Our ref: Birriwa Solar Farm (SSD-29508870)

Subject: Request for Additional Information

I refer to the Birriwa Solar Farm (SSD-29508870). The department is requesting that you provide additional information.

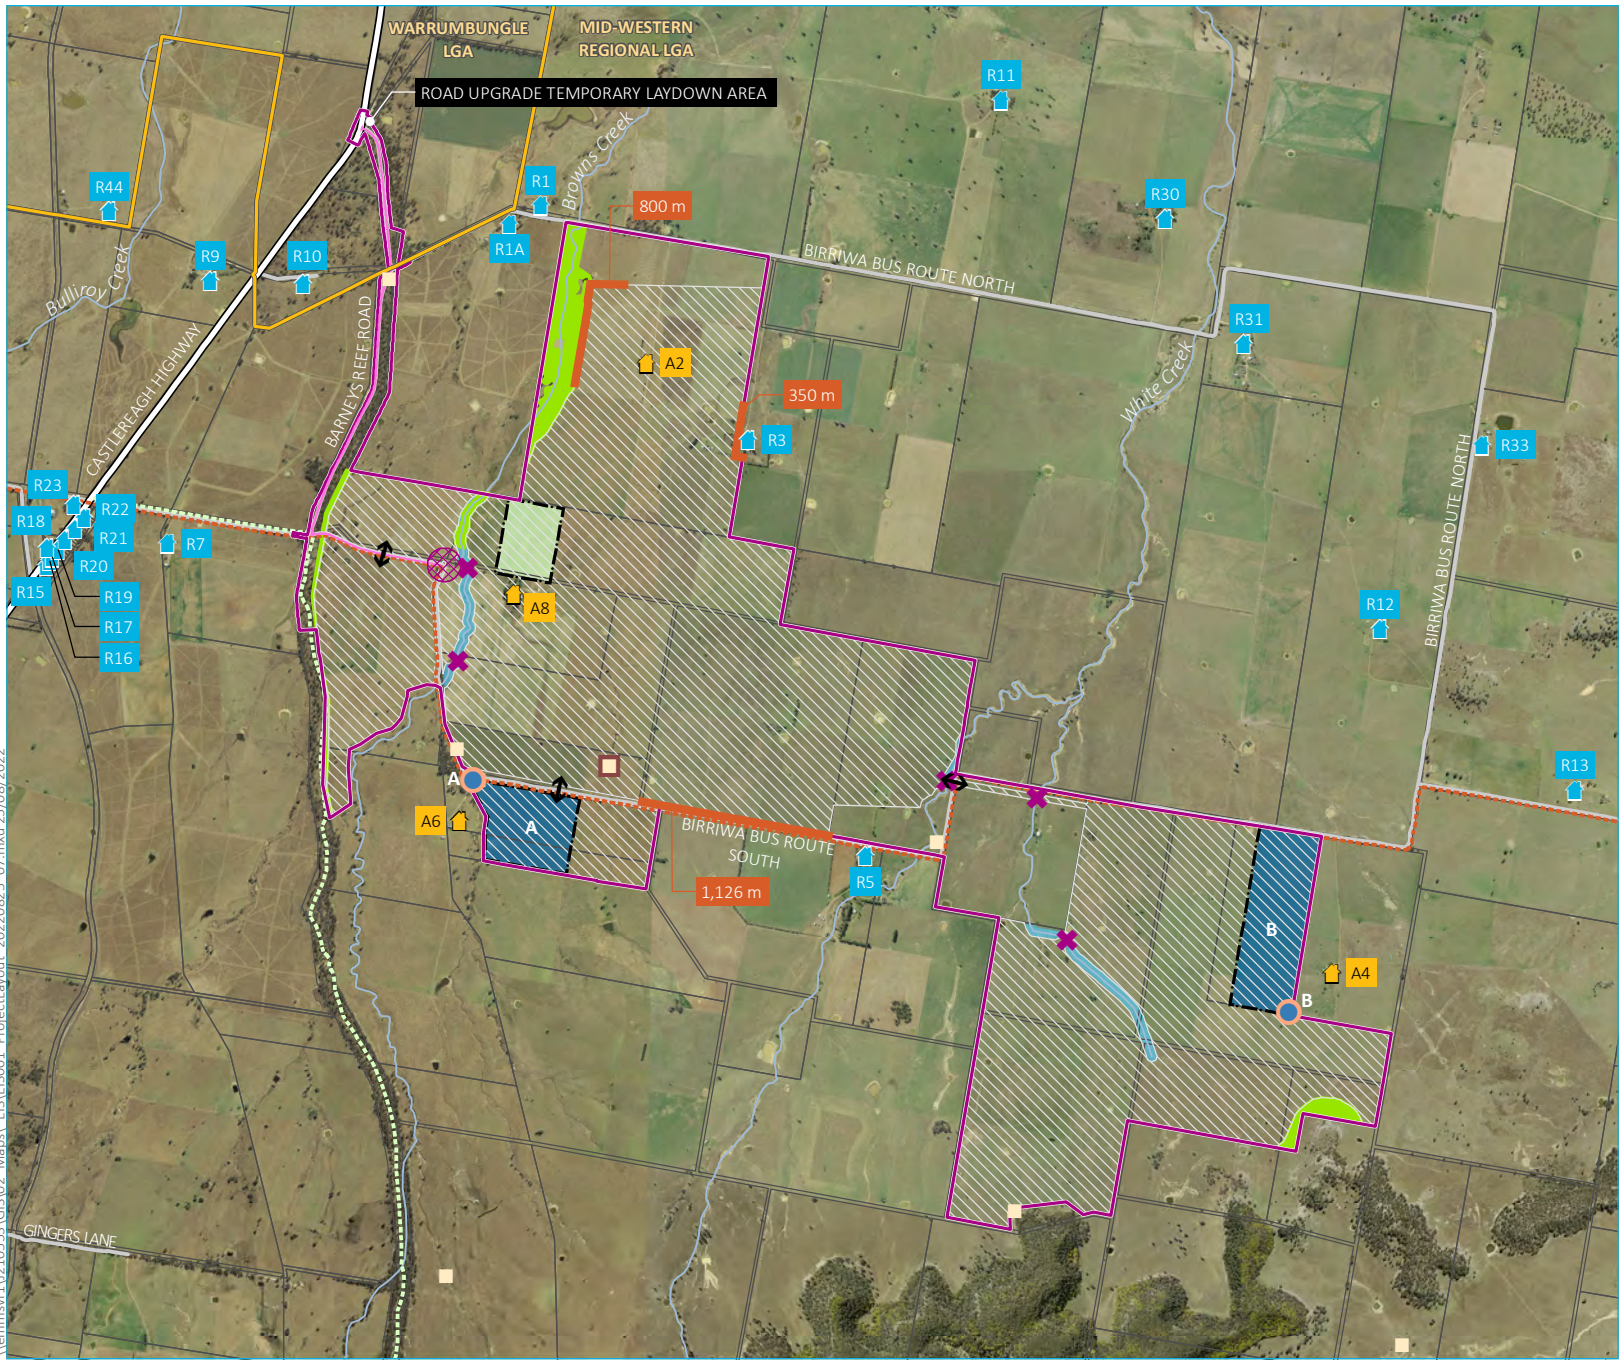
- Confirmation whether the works along Bettington Street, Merriwa are included within the development application, and if so, provide landowners consent covering these works.
- Provide an updated project layout figure which clearly shows:
 - site access points (main access and emergency access)
 - includes a single project area outline in red, rather than separate 'study areas'
